**STATE SIGNIFICANT DEVELOPMENT
ASSESSMENT REPORT:
RPA Hospital Multi-Storey Staff Carpark
(SSD 7542)**

Environmental Assessment Report
Section 89H of the *Environmental Planning and
Assessment Act 1979*

March 2017

LEVEL 0 GENERAL ARRANGEMENT PLAN

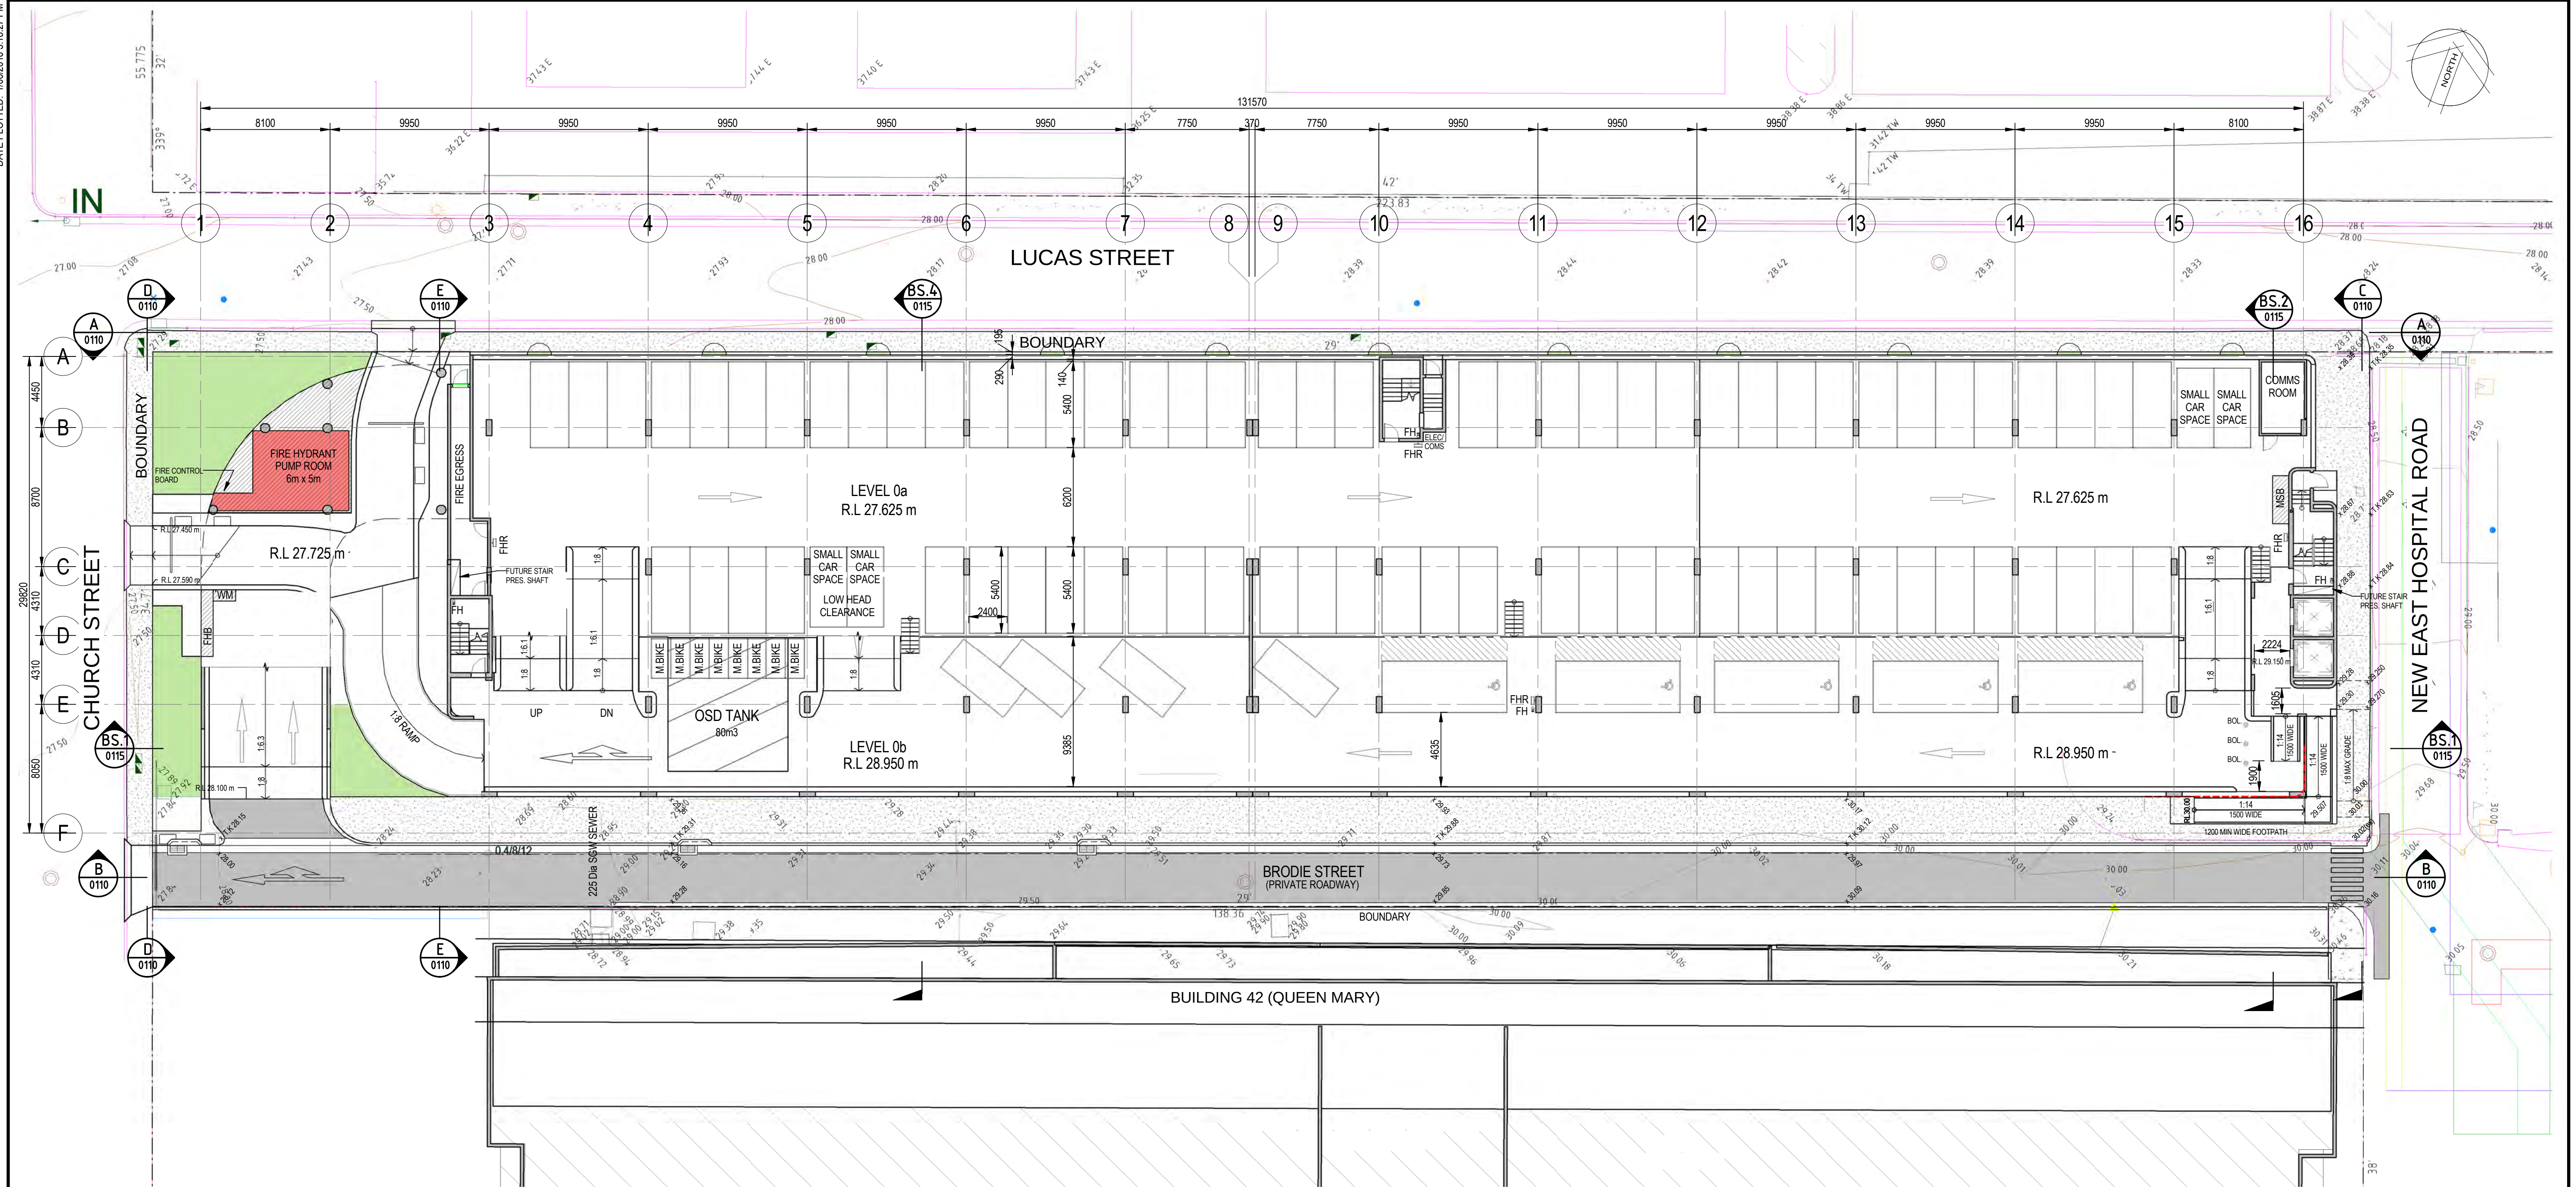
- accessible car parking spaces must be designed in accordance with Australian Standards with a shared area located adjacent to each space;
- traffic impacts at the Carillon Street and Grose Street intersection could be reduced if egress from the proposed facility was provided to Fowler Street;

1 North Elevation 1:200

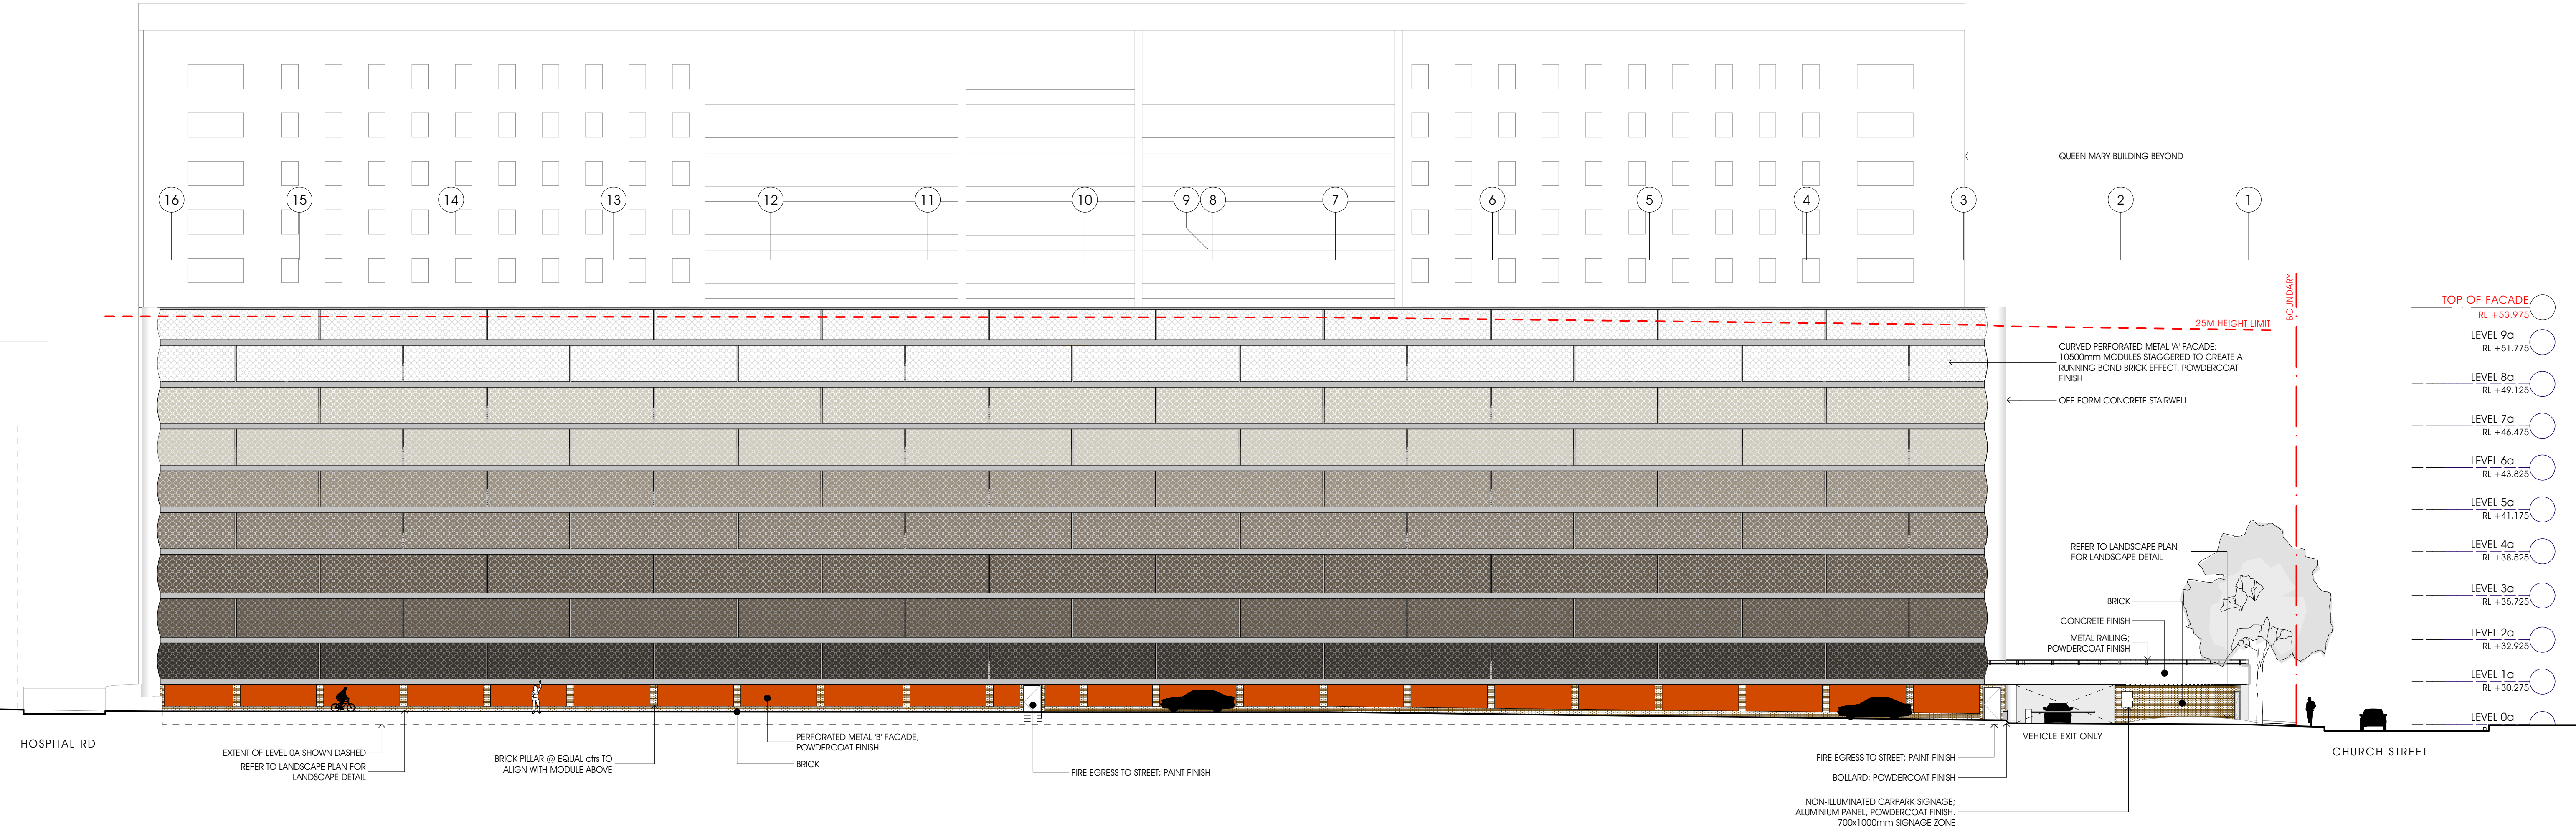
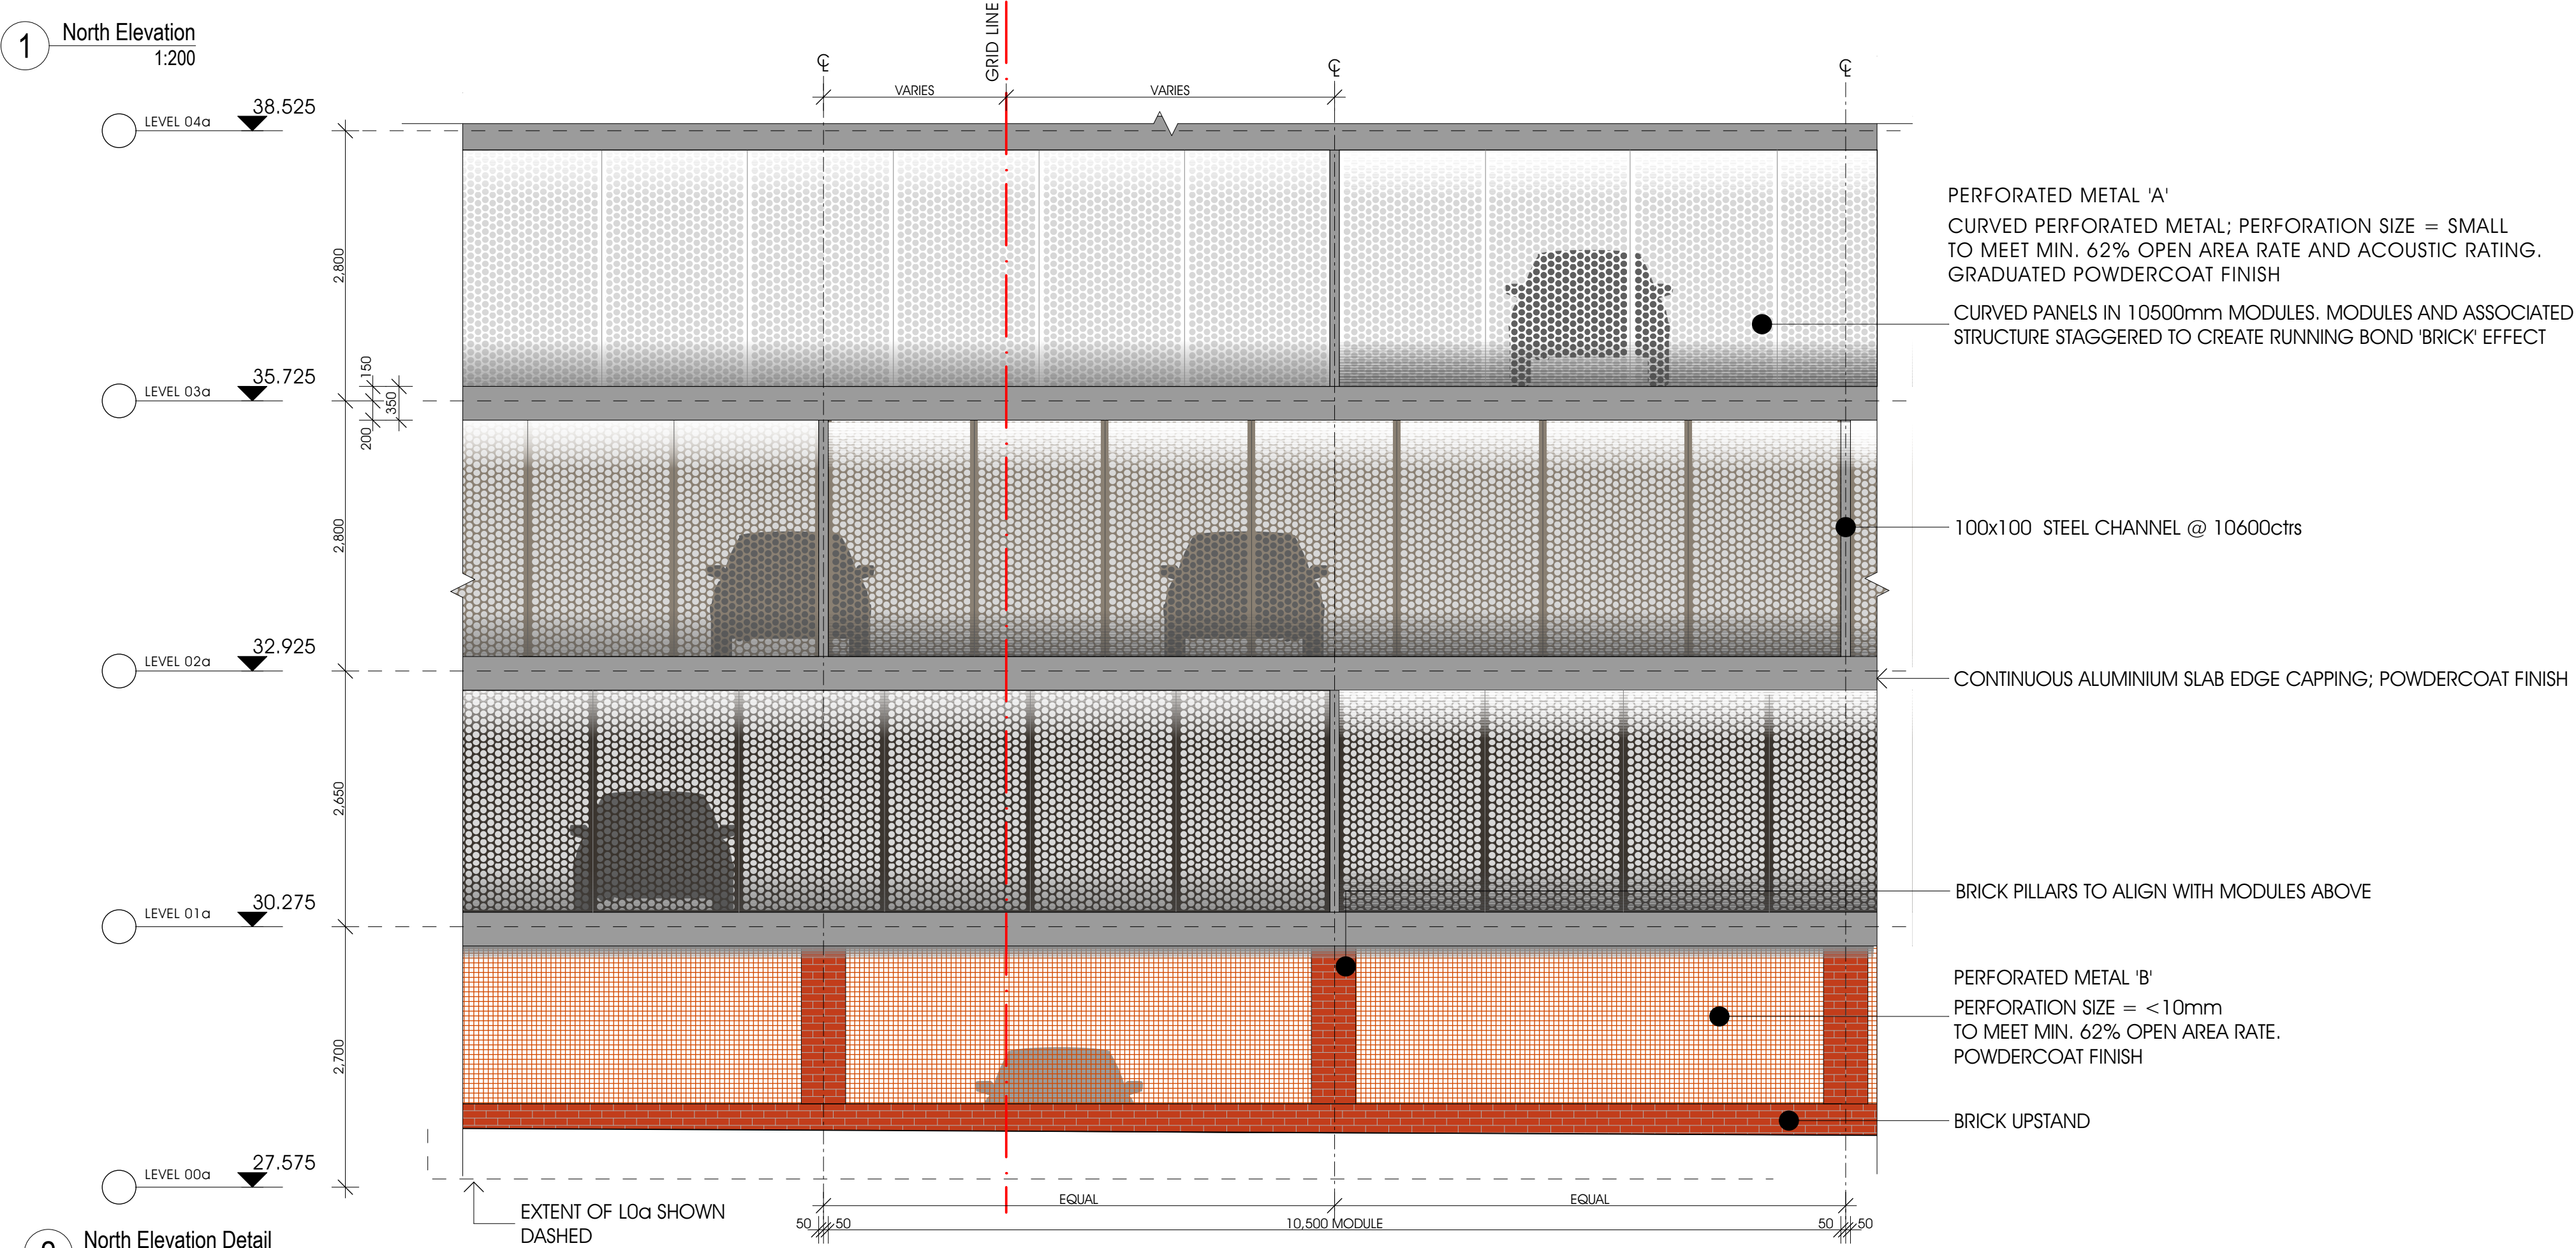
- residential amenity currently enjoyed by the Queen Mary Building will be compromised as a result of the proposal. An improved design response would be to lower the height of the building by providing parking levels underground;

- light spill and overshadowing impacts on adjacent properties should be addressed;
- a detailed signage strategy should be provided; and
- a green roof could be established on the top level of the facility to reduce the impact of urban heat island effect resulting from tree removal and limited landscaping.
